Subject: FW: N of Summer Lane P/35/20/DOC & P/37/20/DOC

We have the following comments regarding the revised surface water drainage details submitted for P/35/20/DOC and P/37/DOC.

Further ADC drainage comments. N.B. Strike throughs indicate comments that have been resolved.

Headwall SW-9

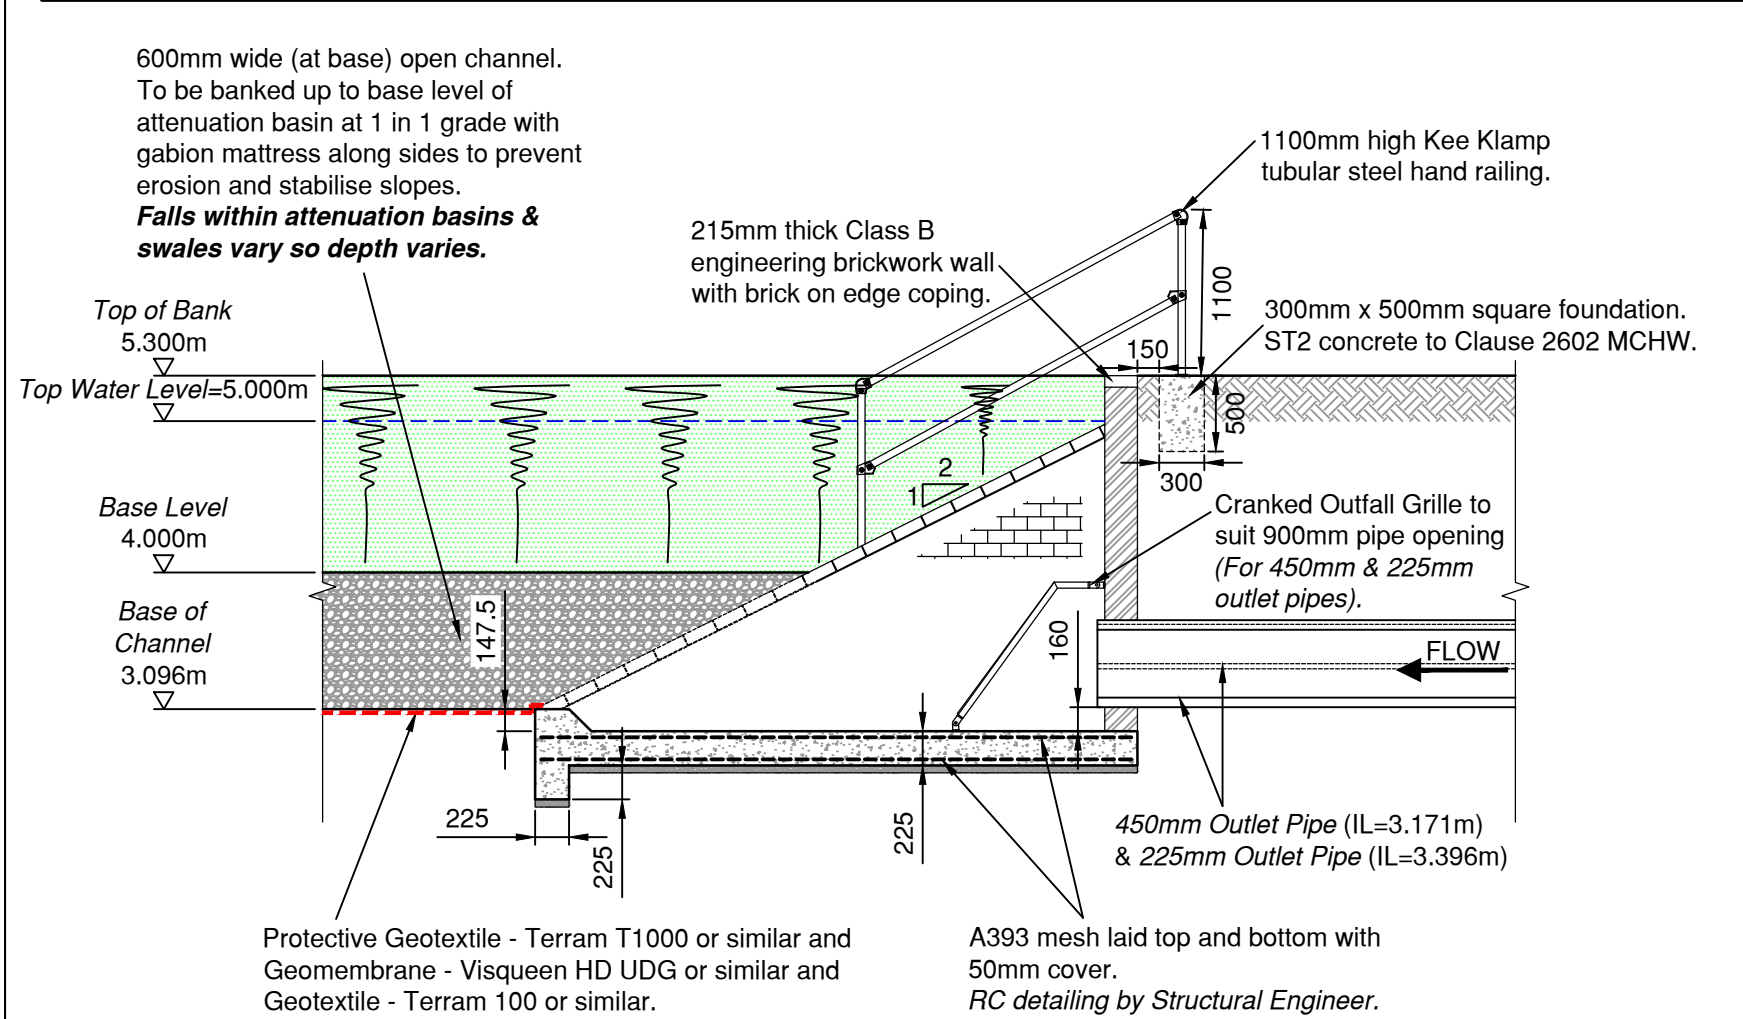
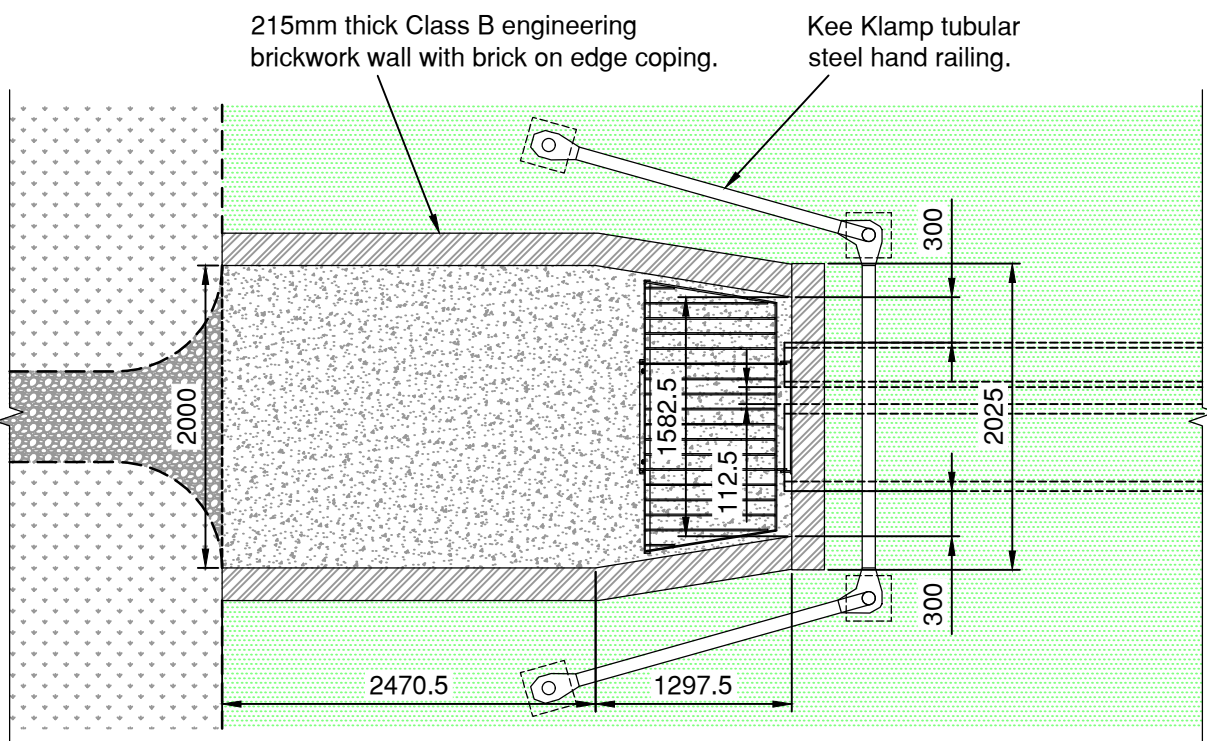
9. All headwall grilles to be cranked as opposed to be flat or just sloped faced. Headwalls SW-4, SW-5, SW-9, SW-13, SW-29 and SW-32 updated to cranked grilles. *Headwall SW-9 cross-section grille not shown (layer not visible?), please ensure this is visible on drawings. Please remove note to Sewers for Adoption, please add construction detail showing typical grille, ensuring that bar spacing, materials, point of lock are shown.*

Headwall SW-32

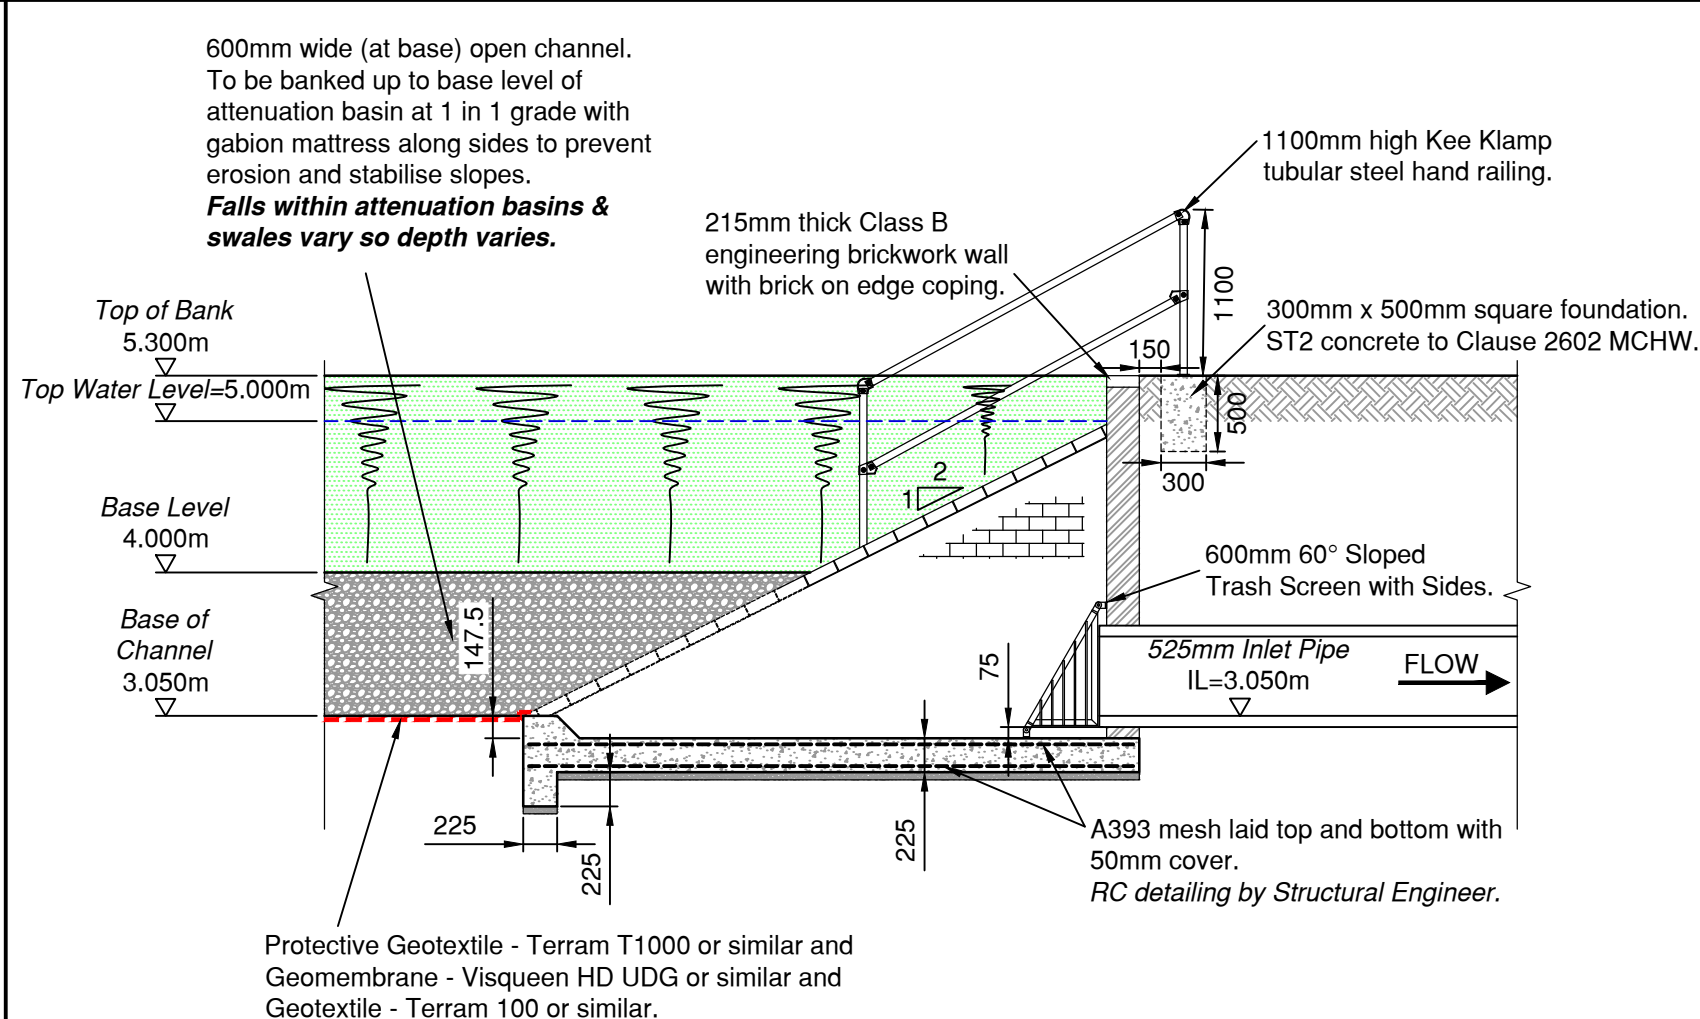
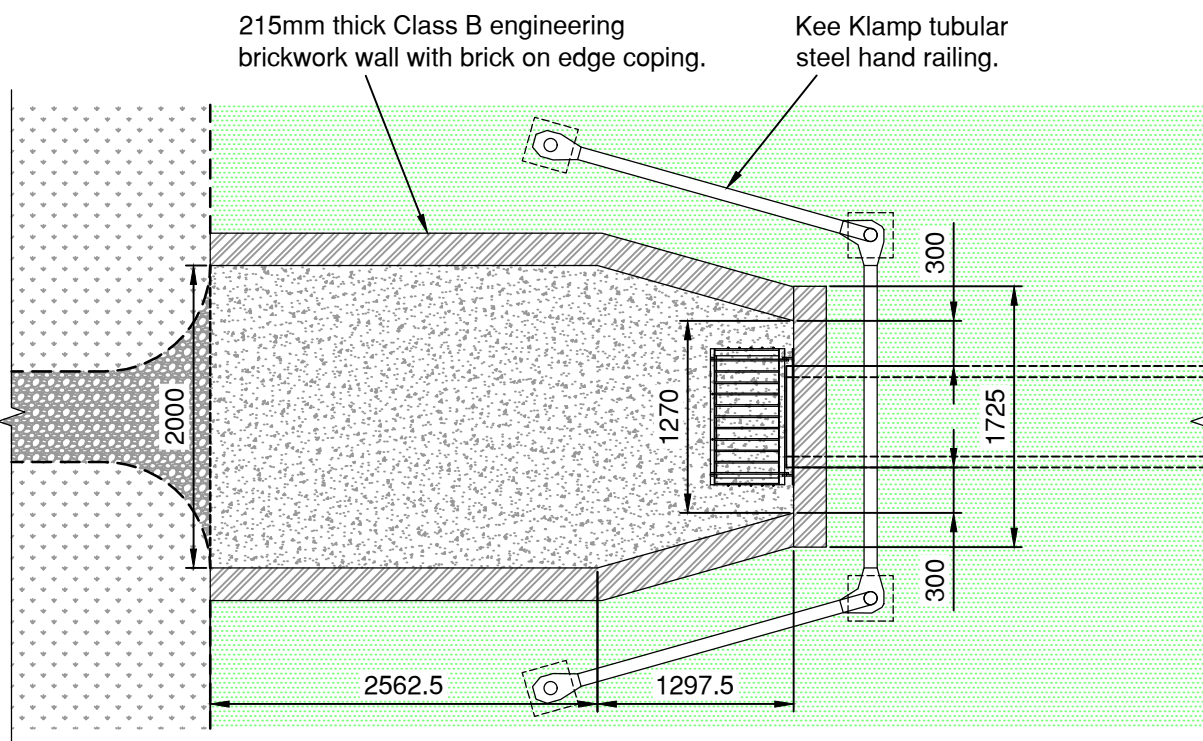
17. Incoming pipes at headwalls SW-4, SW-5 and SW-32 – increase freeboard between pipe inverts and basin/swale bed. *The base of the pipe work connects to the drain bed level, which is specifically deepened to accommodate the incoming pipework levels and eventually connect onto the downstream watercourse. This is a similar arrangement to the main drainage channel running through the swale associated with headwalls SW9 and Sw13. Understand the difficulties here, however minimum of 150mm above pipe inverts and base of swale should be provided.*

44. Headwall SW-32 – investigate connecting the 450mm and 225mm pipes together via a manhole before connection to the headwall or alter upstream arrangement to ensure both pipes connect to headwall in parallel. – *Already actioned as part of subsequent update*

Headwall SW-14

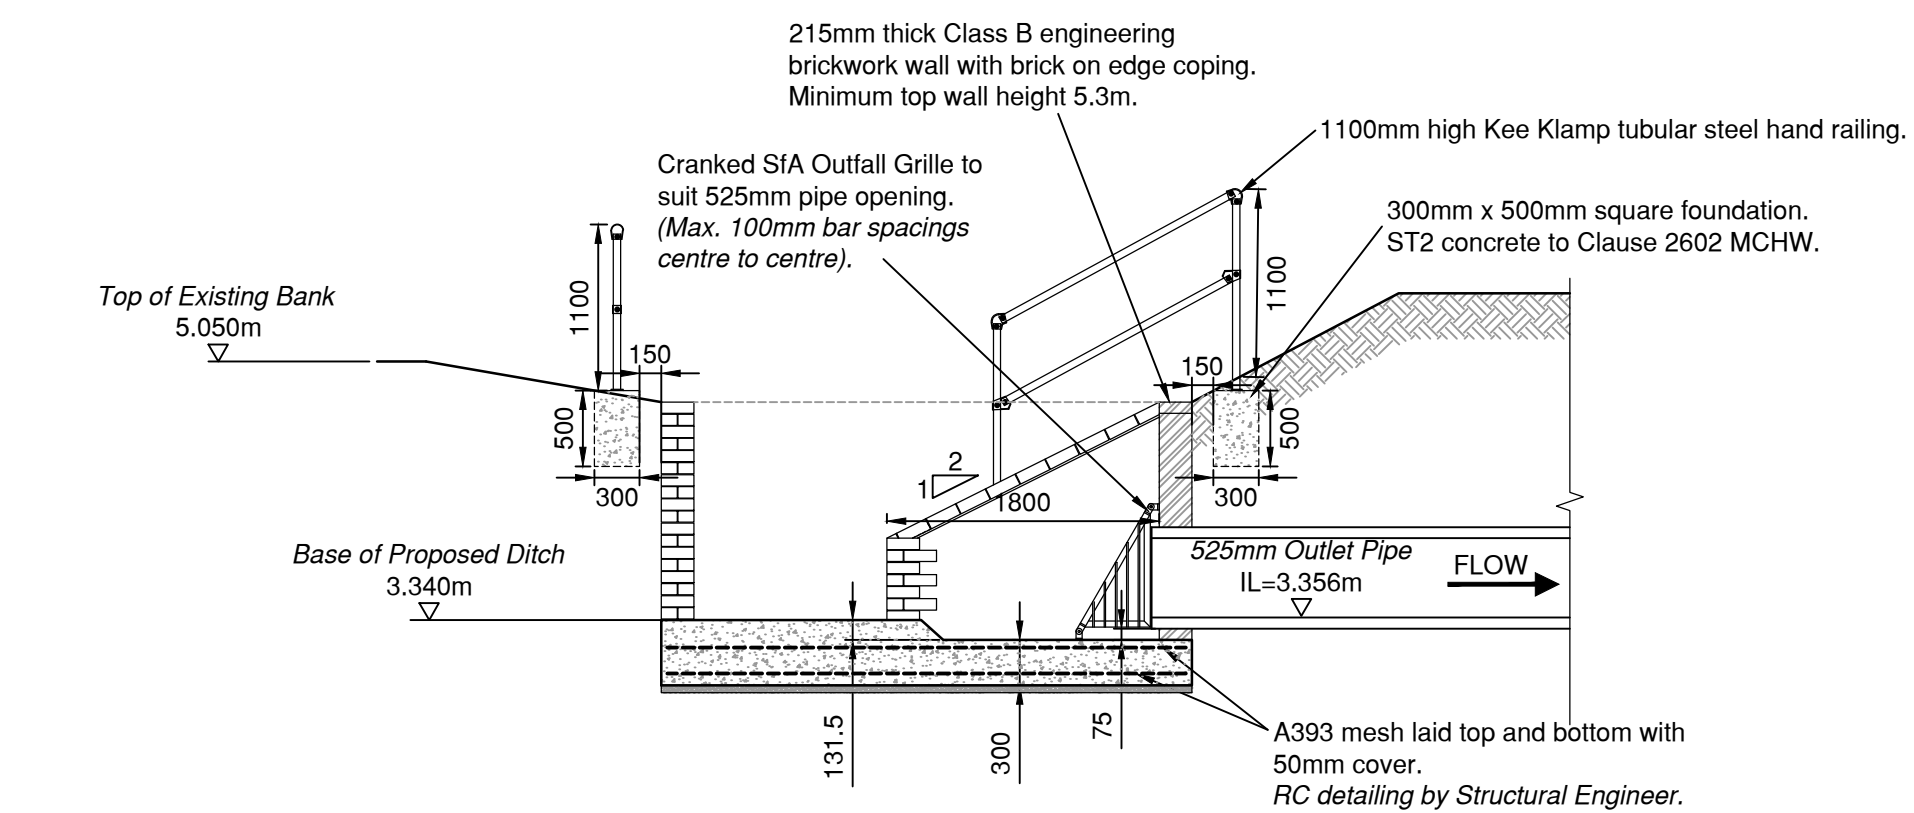
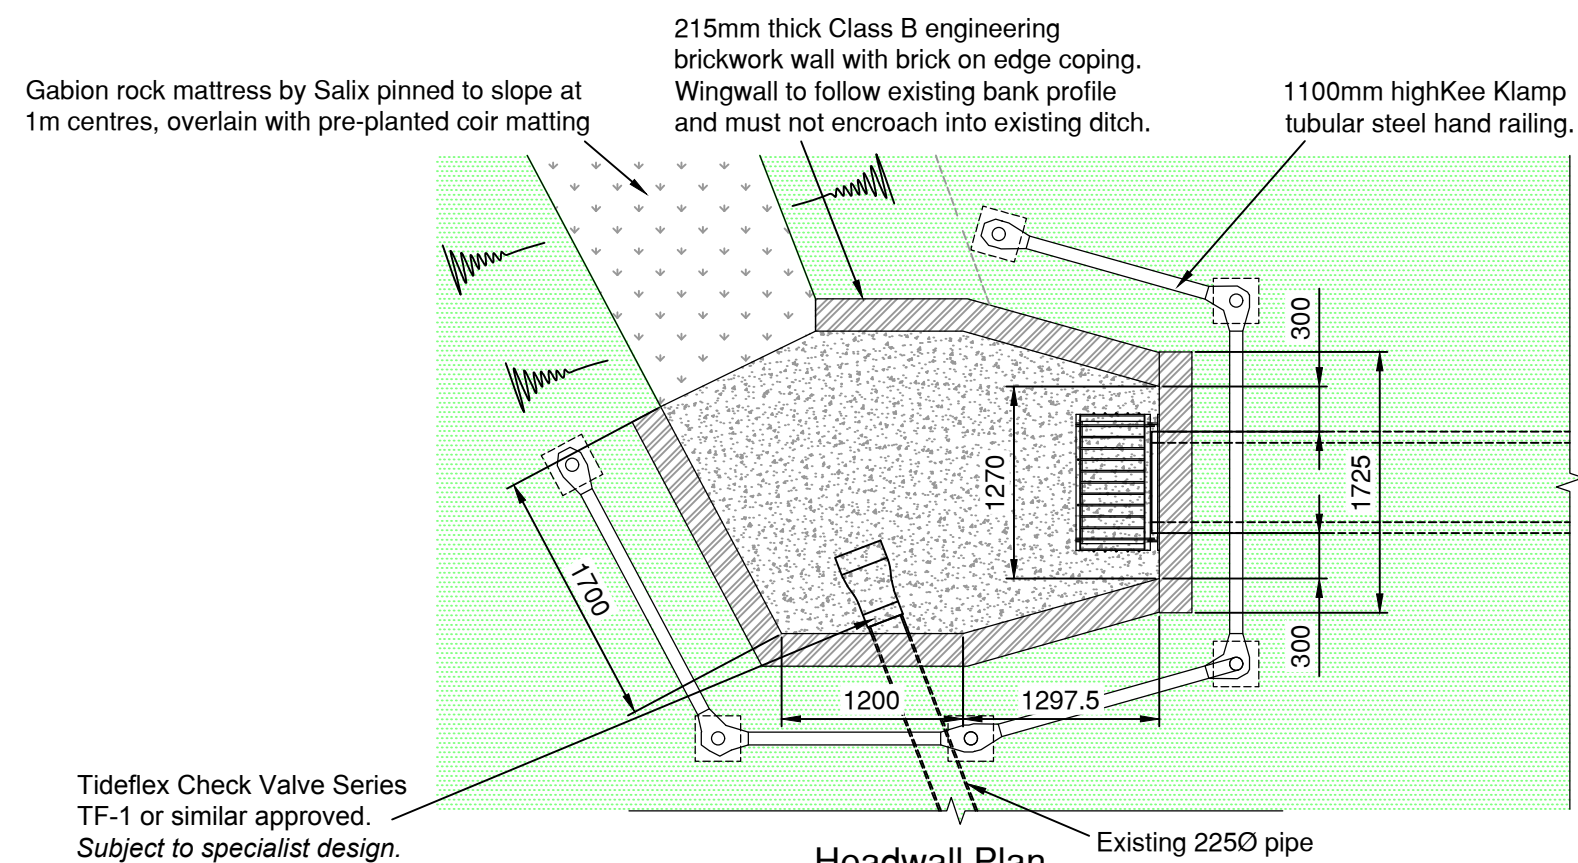
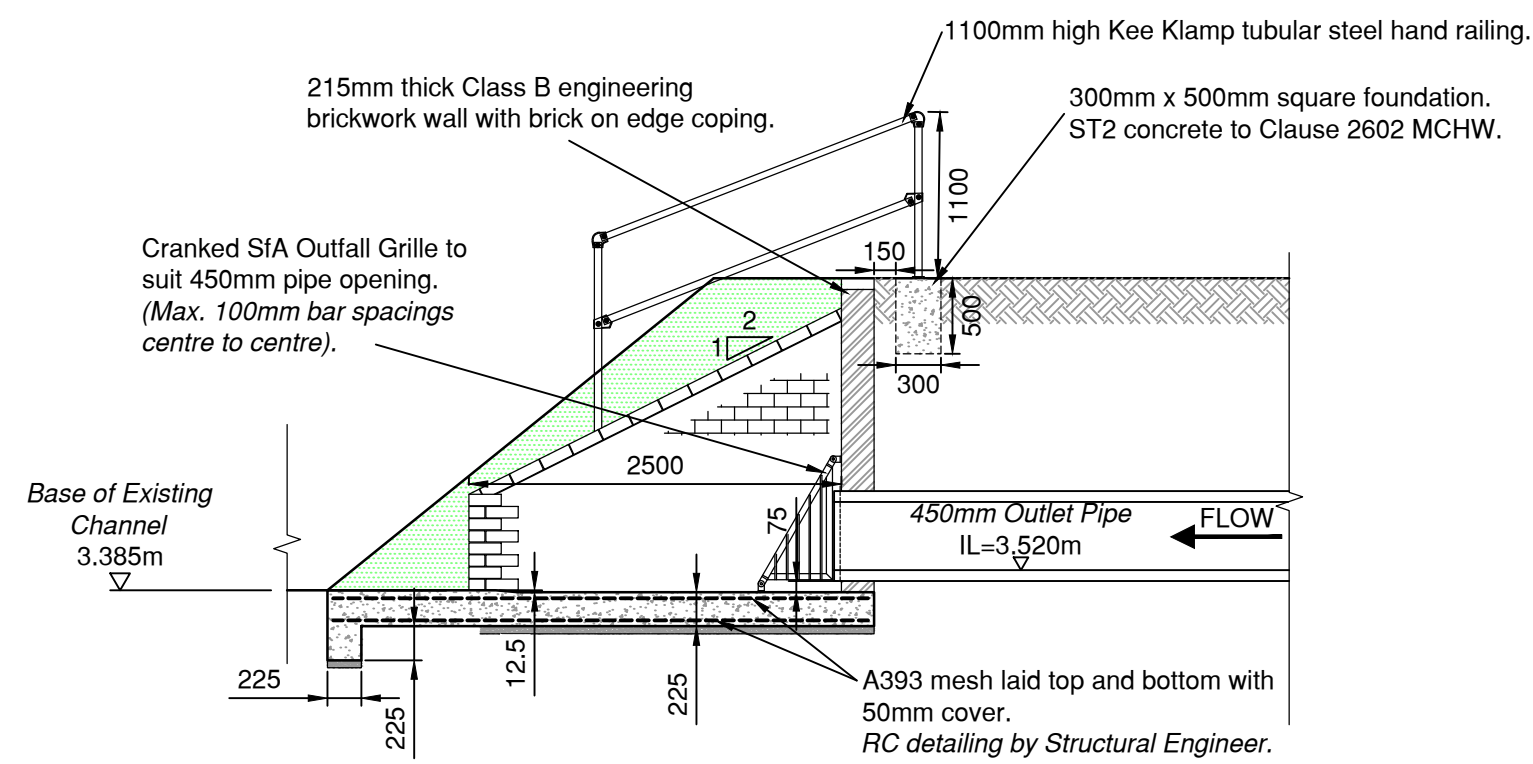
10. Provide construction detail for headwall SW-14. Per OWC – will be provide a copy of these along with this response as well. *Unclear where this is included in details, please provide.*

Headwall SW-15

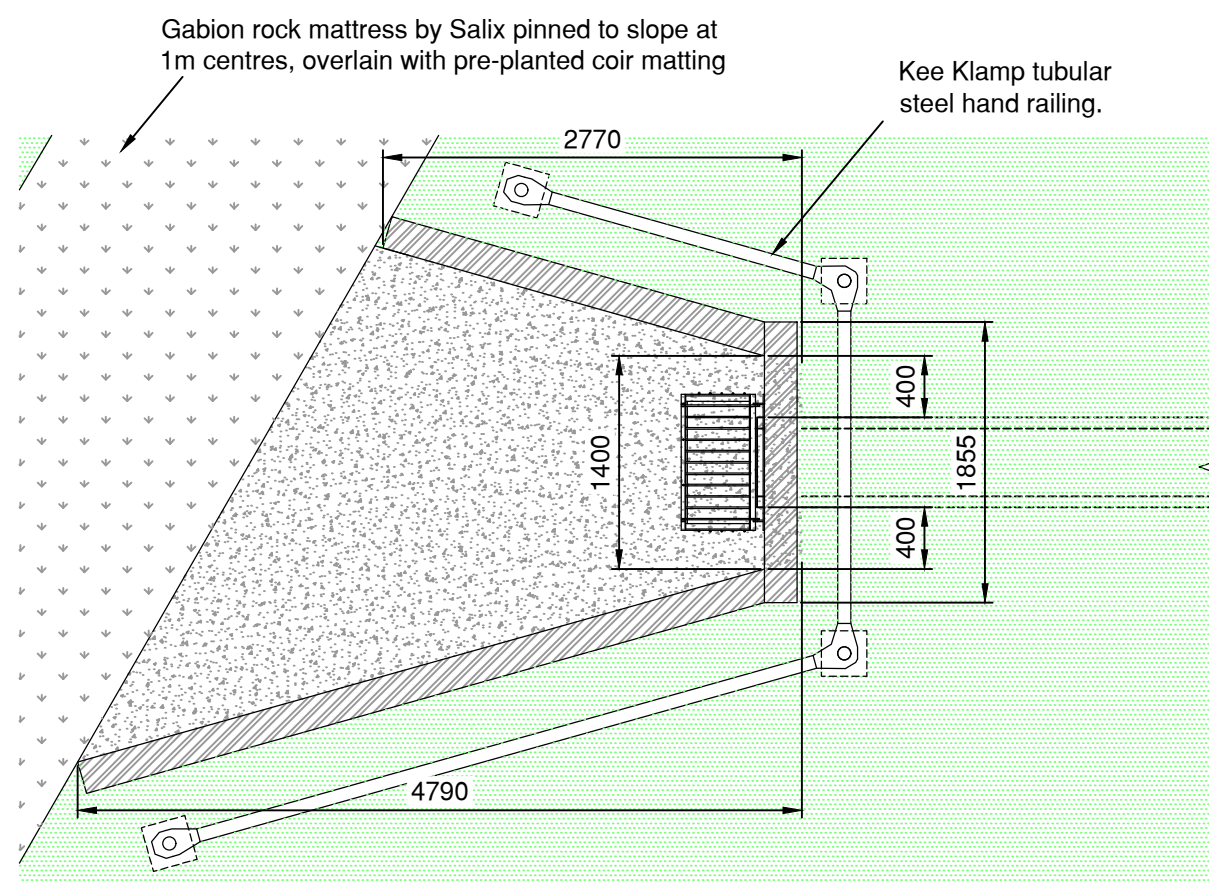
40. SW-16 to Headwall – improve gradient to min. 1 in 400, ensuring as much freeboard as possible between pipe invert and ditch bed. Longitudinal section doesn't appear to show the SW-16 to SW-15 arrangement as per the layout plan ie. SW-15 is a headwall not a manhole. *Per OWC – will be provide a copy of these along with this response as well*
